SSDA 5752-2012 – SYDNEY INTERNATIONAL CONVENTION, EXHIBITION AND ENTERTAINMENT PRECINCT, PPP COMPONENT

Further to the Response to Submissions and Amendments to Proposed Development submitted to the Department of Planning & Infrastructure (the Department) on 28 June 2013 the purpose of this letter is to make further minor amendments to the proposed PPP development.

The minor amendments proposed are:

DRAWING TITLE
 PPP WORK-PRECINCT PLAN

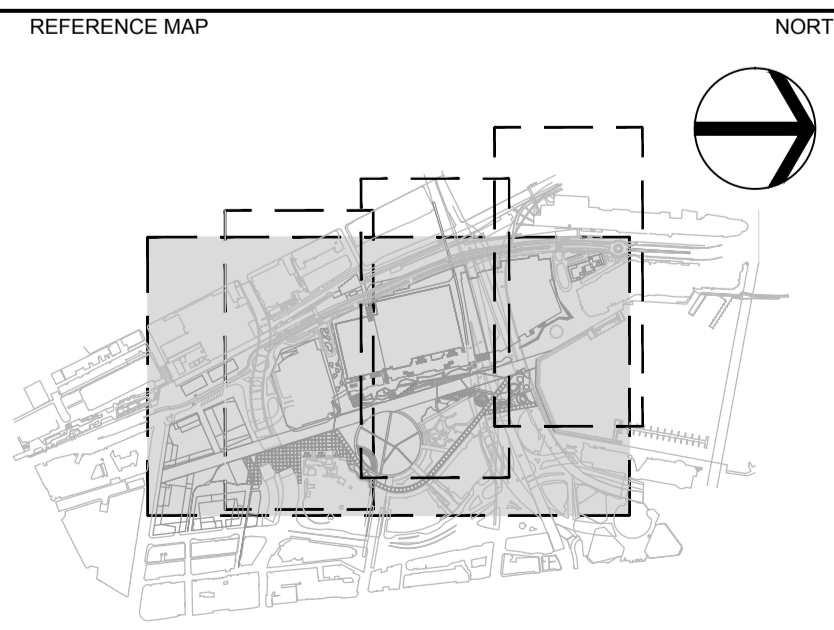
- Deletion of all proposed physical works (civil and landscaping) from a small area of land (comprising approximately 270m²) located at the north eastern corner of Darling Drive and Harbourside Place. All works in this location will now be the subject of the separate future SSDA for the Hotel proposal; and
- Minor changes to kerb line and median strip on Darling Drive to the immediate west of the future Hotel site to accommodate footpath and landscaping in front of the future Hotel.

The current PPP development scheme as submitted to the Department with the Response to Submissions and Amendments to Proposed Development in June 2013 proposes an area of landscaping (paving and trees) at the north eastern corner of Darling Drive in front of the proposed future Hotel building and connecting to Harbourside Place. Refer to Landscape Drawing PP-LA-201 Rev B General Arrangement.

The deletion of civil and landscaping works at the north eastern corner of Darling Drive and Harbourside Place from the PPP development is proposed in order to allow for the final resolution of the configuration of the future Hotel building and its interface with the public domain to be determined through the future separate SSDA for the Hotel. As you are aware it is anticipated that the SSDA for the Hotel will be submitted to the Department in late August 2013.

- Landscape Drawing – PP_LA_003 PPP Work – Precinct Plan Rev C
- Landscape Drawing – PP_LA_201 General Arrangement Rev C
- Civil Drawing – PP – CI – 0401 Civil Works Plan 1 Rev C

GENERAL ARRANGEMENT				
STATUS				
DEVELOPMENT APPLICATION				
SCALE @ A1	DRAWN	CO-ORD	REVIEWED	APPROVED
1:500	JC	DG	AB	AB
PROJECT NUMBER	DRAWING NUMBER		REV	
003688	PP_LA_201		A

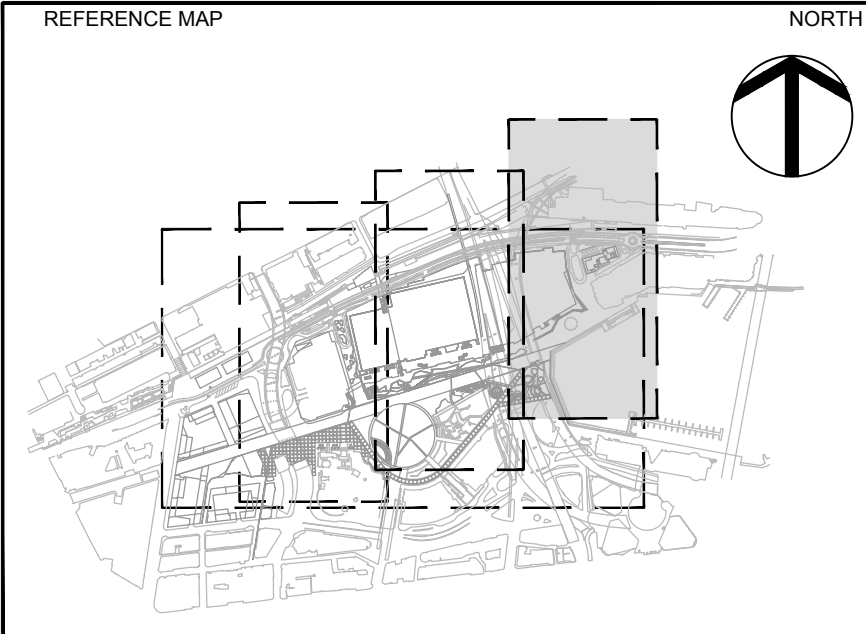
It is noted that a corresponding increase in useable public space in this location is anticipated to be delivered via the Hotel SSDA once the final detailed design of the hotel interface to the public domain is known. In addition, the minor adjustment to the kerb line and median strip on Darling Drive will also allow a footpath and landscape zone in front of the future Hotel facing Darling Drive.
